Our Case Number: ABP-309770-21

Re: Proposed development of up to 15 wind turbines with a tip height of up to 175 metres and laying of approximately 26km of underground electricity cabling to facilitate the connection to the national grid, and all associated site development works
Townlands of Camagh, Carlanstown, Coole, Clonrobert, Clonsura, Doon, Monktown, Mullagh, Newcastle and other townlands, Co. Westmeath

Case Reference: PA25M.309770

We wish to make a written submission / observation to the above SID.

Figure 13-13: Recorded monuments within 5km of the nearest proposed turbine.

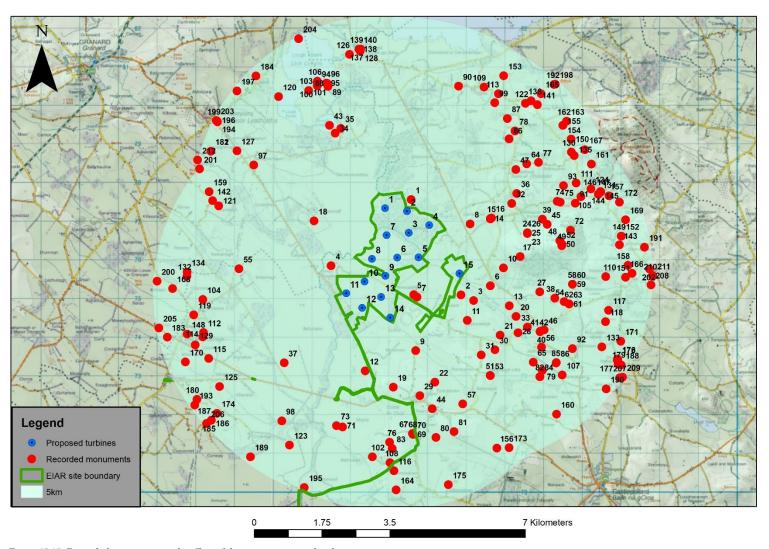
IF there is a find when digging for the turbines, will Coole Wind Farms SID halt their digging? The Mayne Bog has a Bronze age oak road, (71 and 73 Figure 13-13) which was dug up and a lot of it destroyed by peat harvesting.
